Our Ref: M/132/17/HH
Your Ref:

Town & Country Planning Act 1990 (as amended)
Town & country Planning (Development Management Procedure) (England) Order 2015
Application for Planning Permission for Works or Extension to a Dwelling

Development Single storey rear extension (resubmission following M/69/17/HH).

Location 1 Hadley Close Middleton on Sea

Existing (South) Rear Elevation  
Scale 1:100

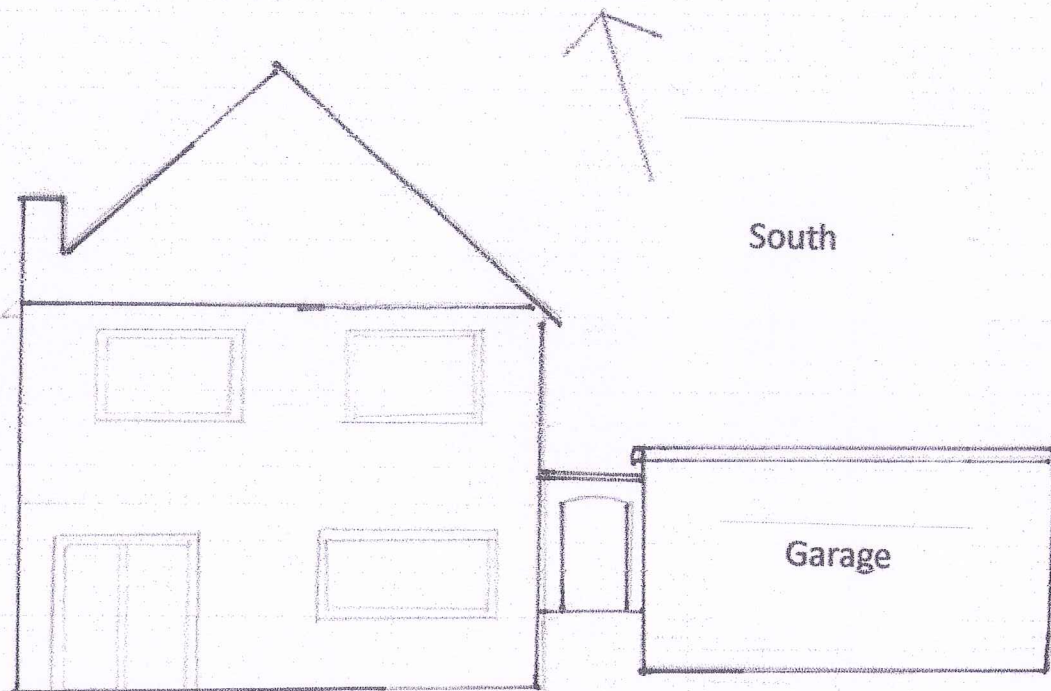
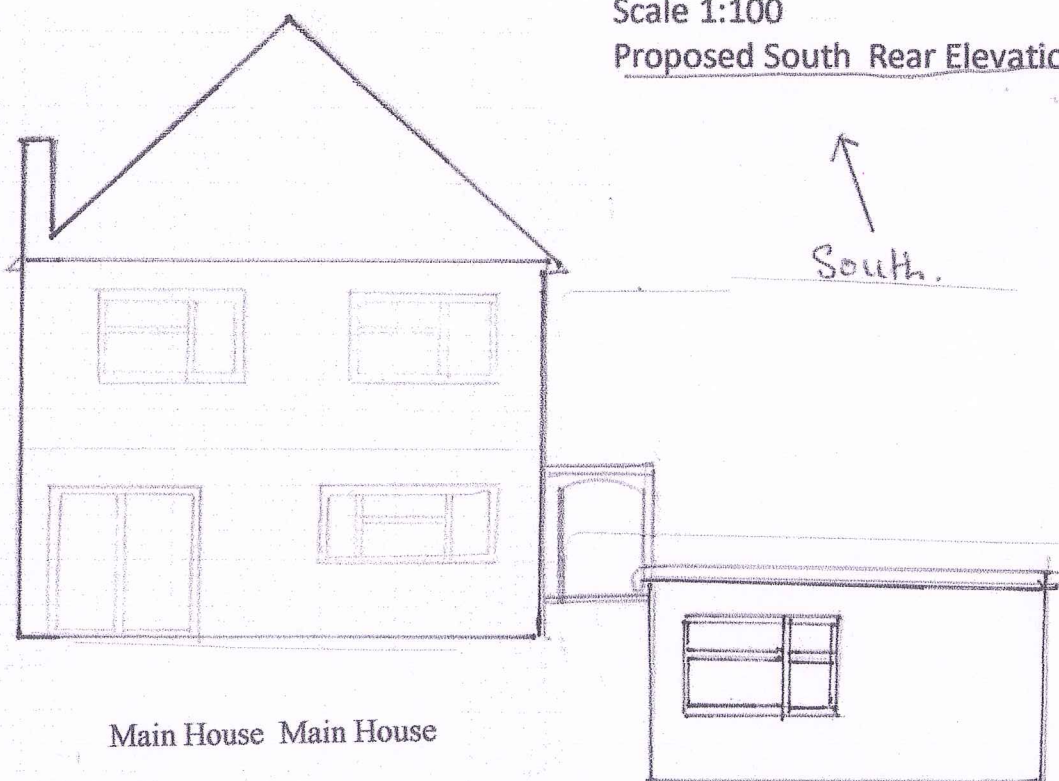
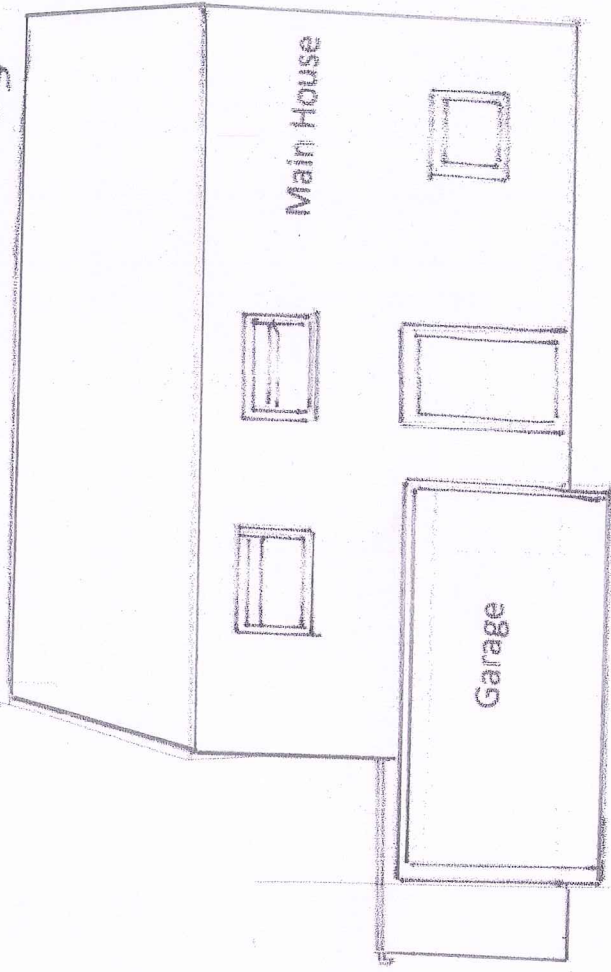
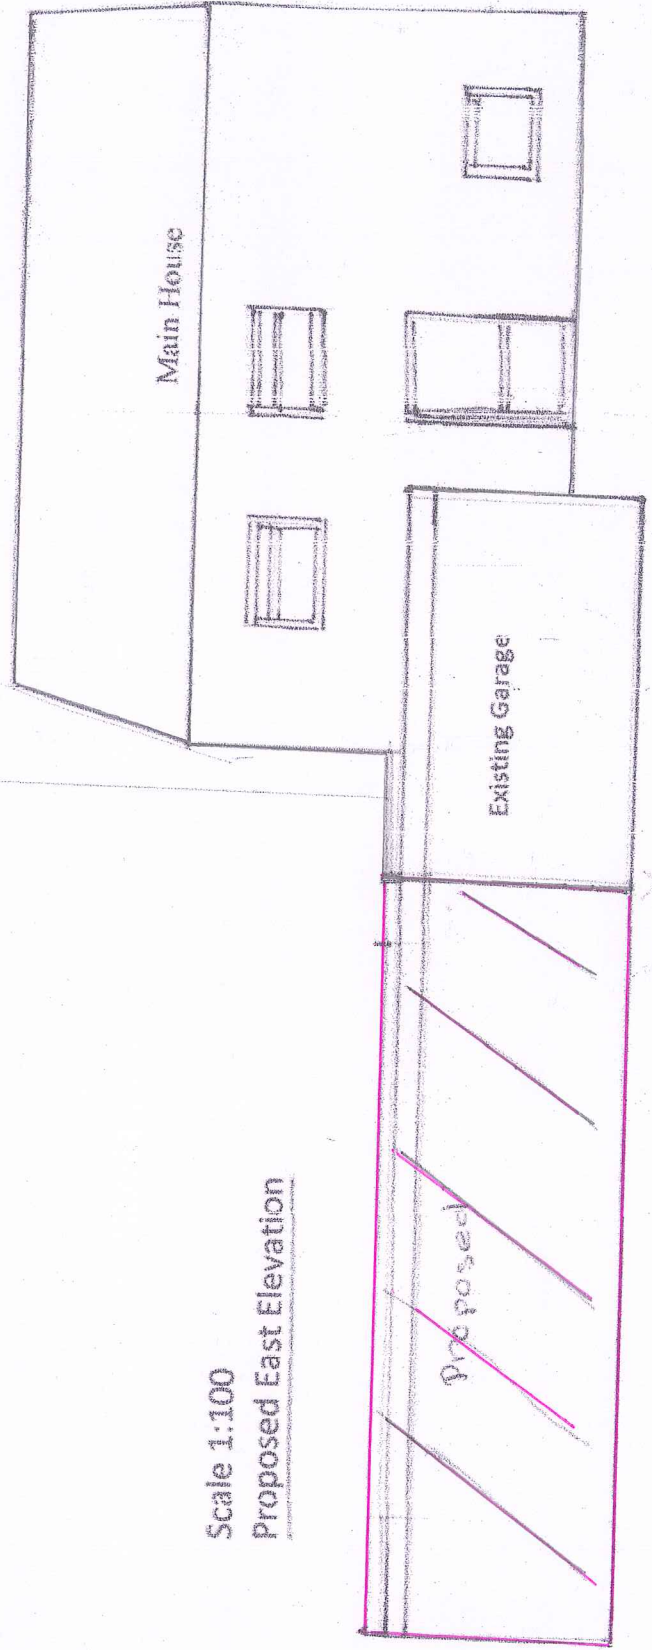
The existing floor plan and existing elevations do not accord. Please amend accordingly.
